## Application for a Non-Material Amendment Following a Grant of Planning Permission

Construction of granny annexe in rear garden.

20/0857/HSE

Building rotated: dimensions remain unchanged, distance from the boundary remains unchanged.

PROPOSED GROUND FLOOR PLAN - BUILDING ROTATED (DIMENSIONS REMAIN UNCHANGED), DISTANCE FROM THE BOUNDARY REMAINS UNCHANGED.

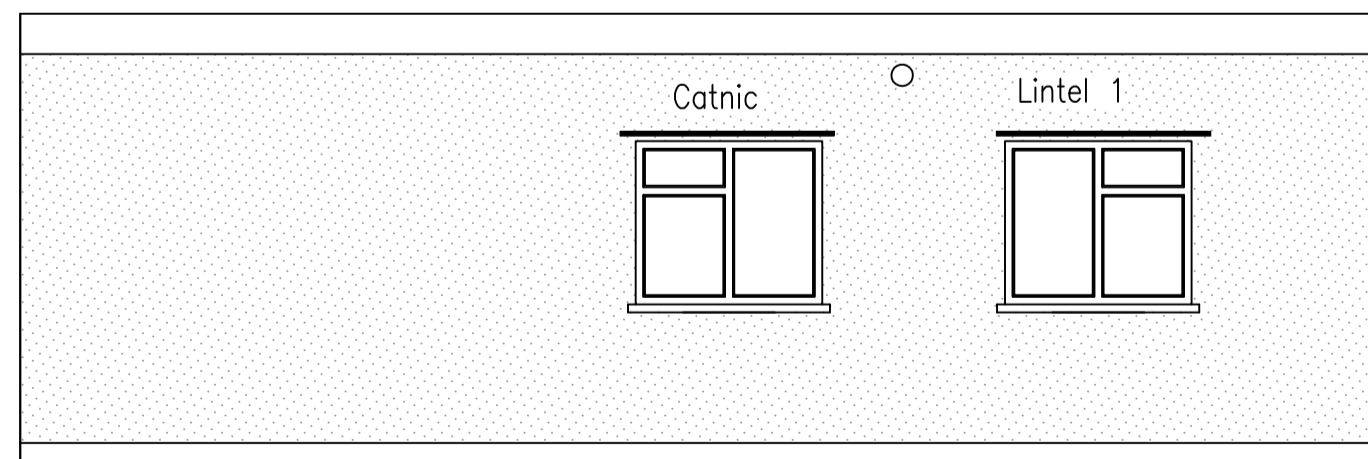
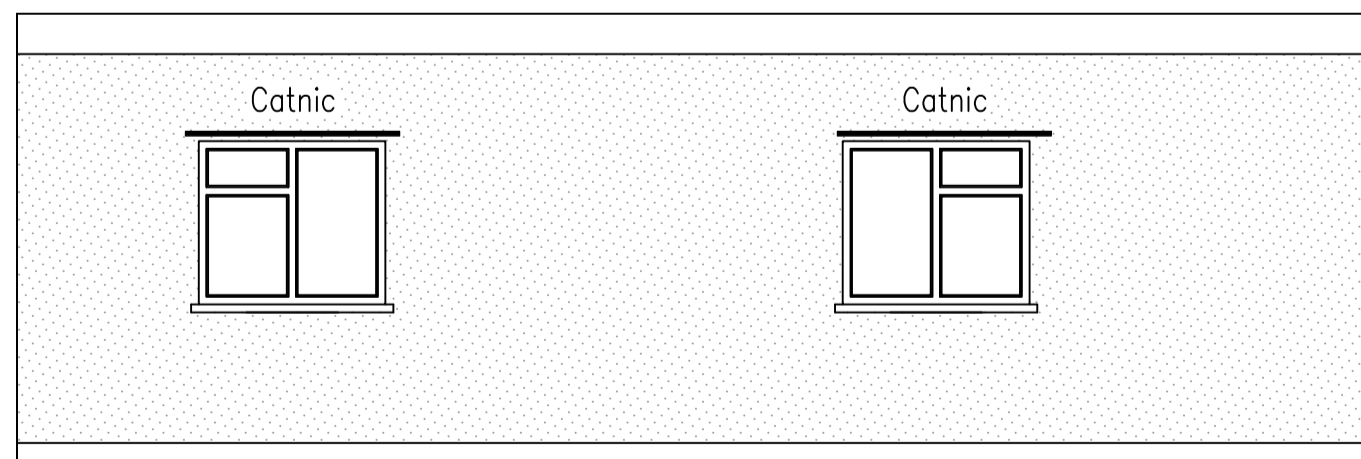
The owner prefers to mirror the building.
